WEST SUSSEX COUNTY COUNCIL CONSULTATION

TO:	Arun District Council FAO: Silvie Steiningerova
FROM:	WSCC – Highway Authority
DATE:	16 October 2025
LOCATION:	Land West of Holly Drive Littlehampton
SUBJECT:	LU/184/25/DOC Approval of details reserved by condition imposed under LU/47/11/ relating to conditions 21-Ecological Management Plan, 22-Construction Method Statement, 23-details of construction compound and 26-Roads Construction Programme (see LU/185/25/DOC for approval of details reserved by condition imposed under LU/47/11/ relating to condition 10-surface water drainage). An amendment received to the above application dated 19th September 2025 relating to: Conditions 21, 22, 23 and 26. Substitute construction method statement received on 29th September 2025. Construction Method Statement Rev 4 received on 10th October 2025.
DATE OF SITE VISIT:	n/a (desktop study undertaken – site visited previously)
RECOMMENDATION:	Advice

Comments below solely respond to conditions 22, 23 and 26 (found in Construction method Statement produced by Persimmon Homes Ltd., Revision 04, September 2025).

Dwg. No.	001.1.TVAL.0100	Rev	P1
----------	-----------------	-----	----

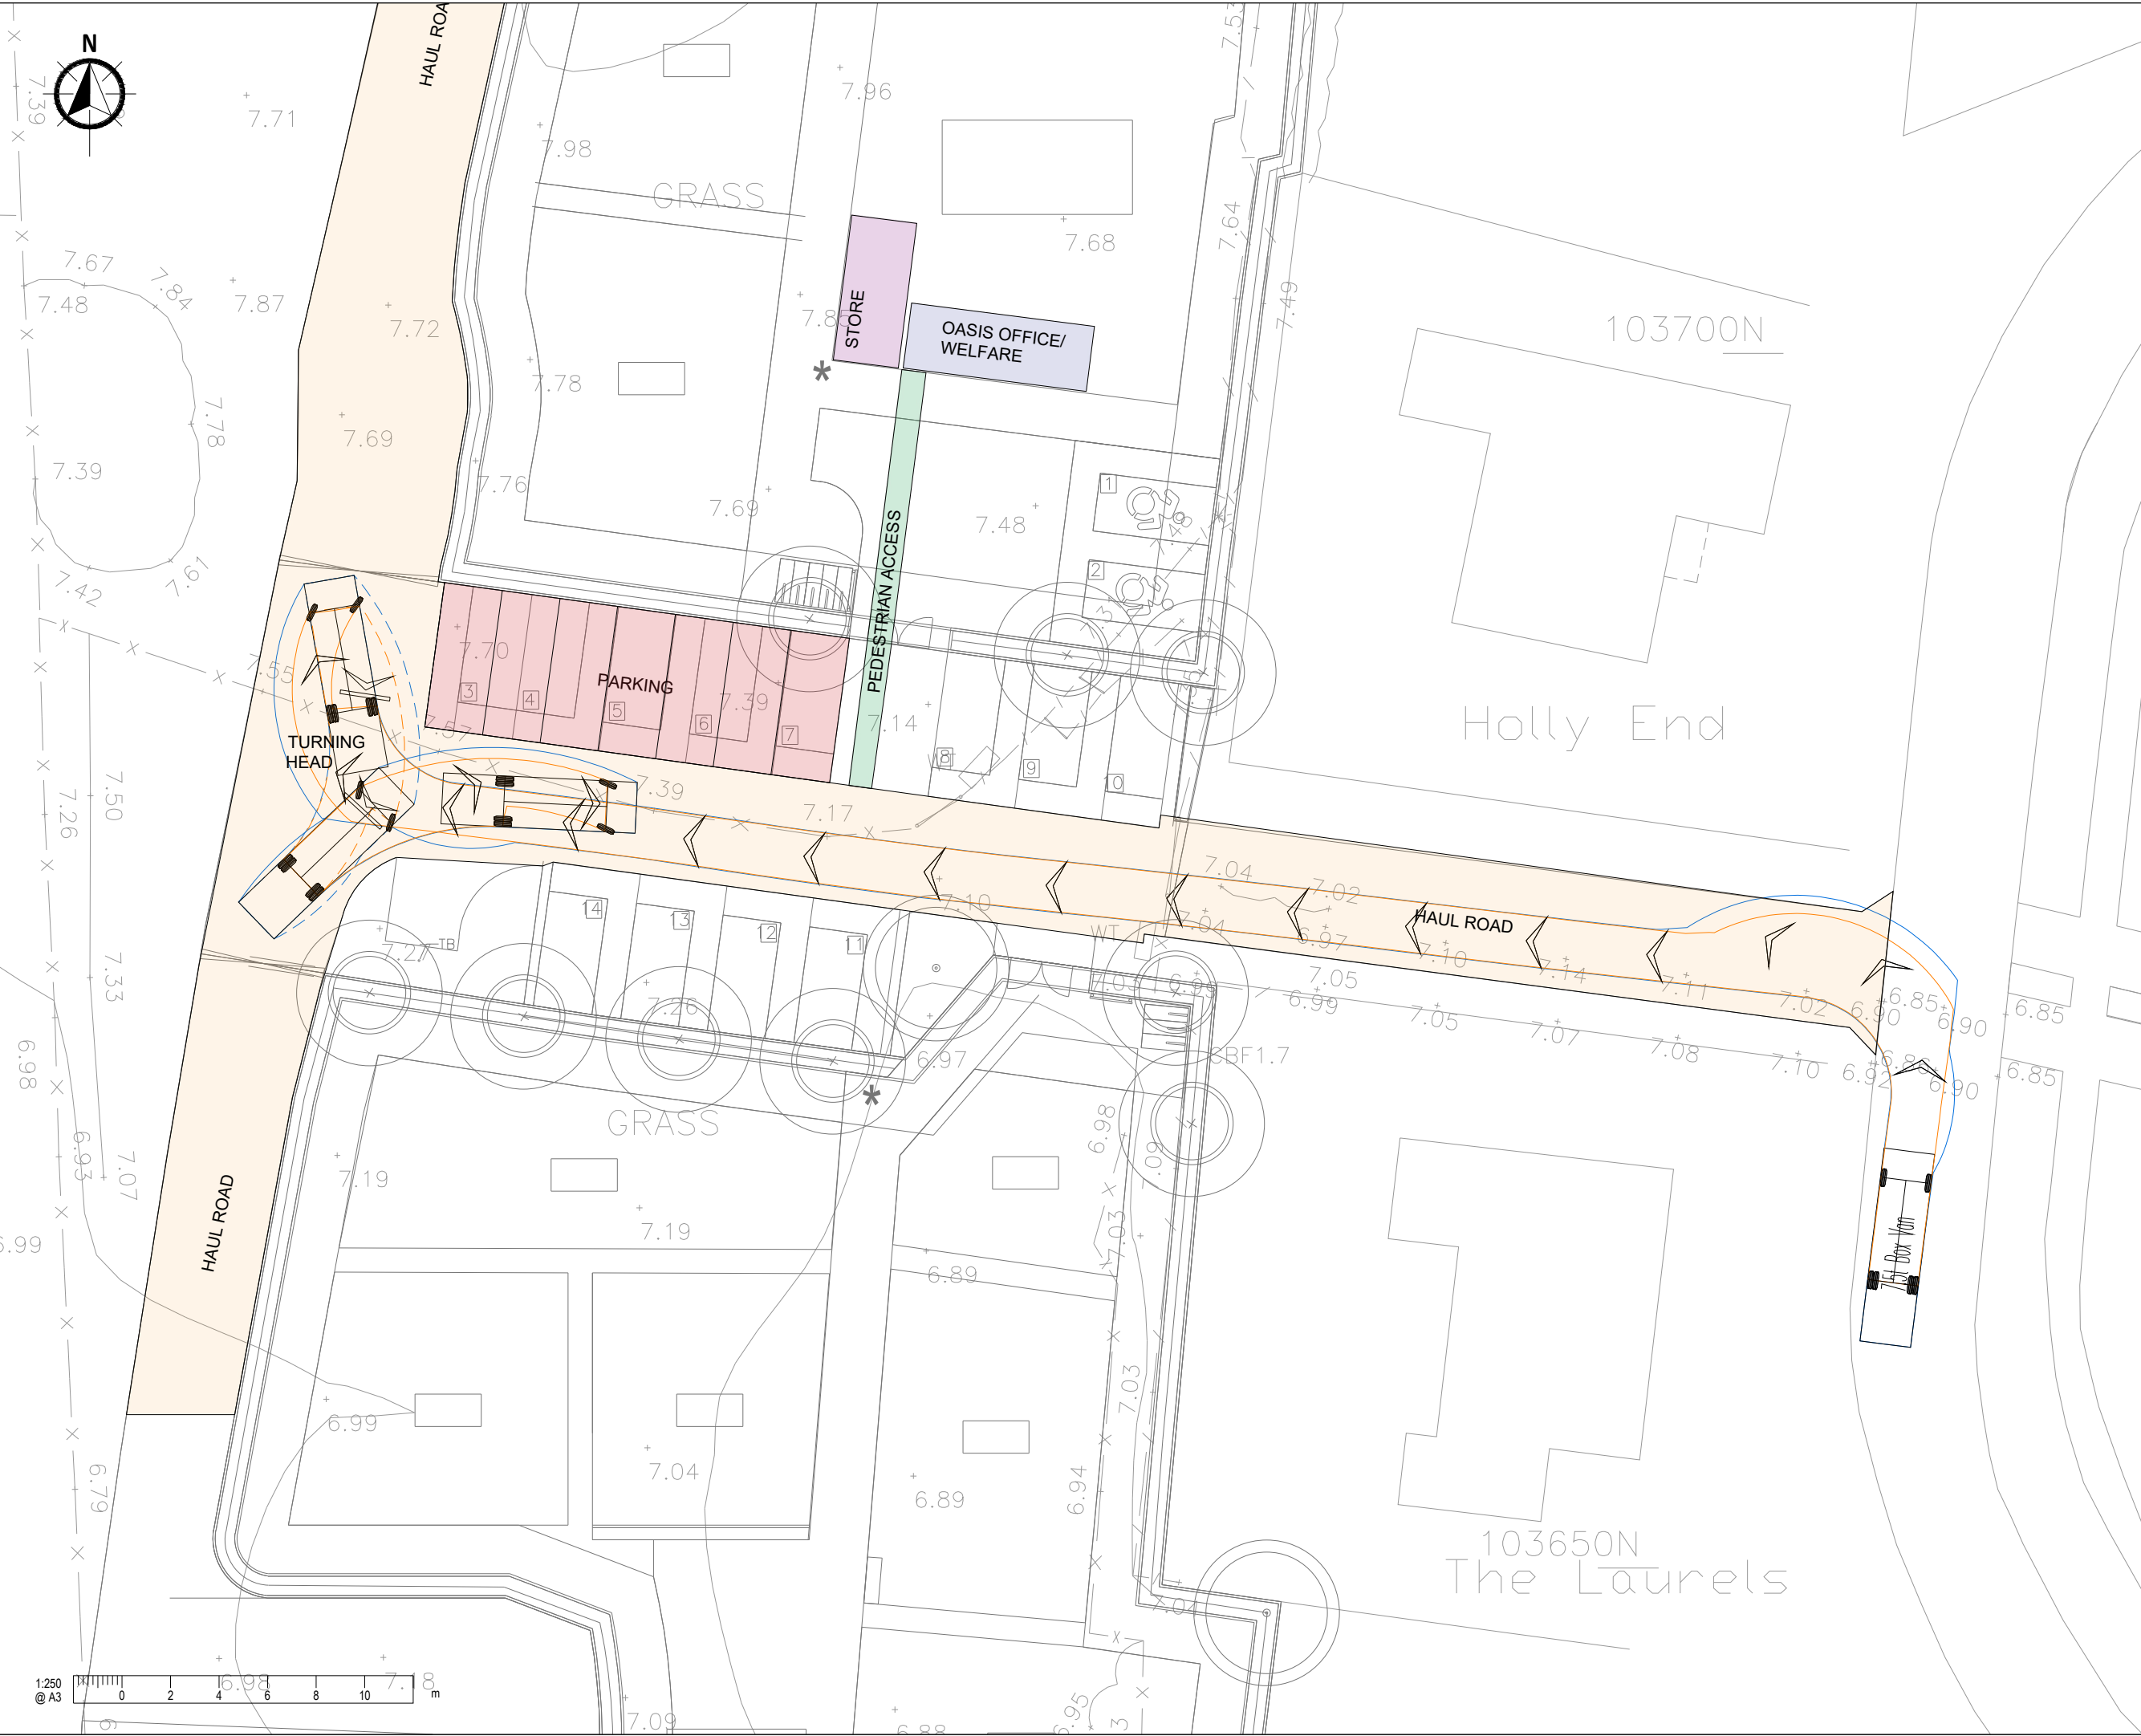
With regard to the traffic routing, the Highway Authority would not wish to see construction traffic entering and leaving the site from the northern part of Toddington lane in order to avoid the railway level crossing and the narrower parts of the lane in that direction. Therefore, traffic should only enter and leave the site from the south.
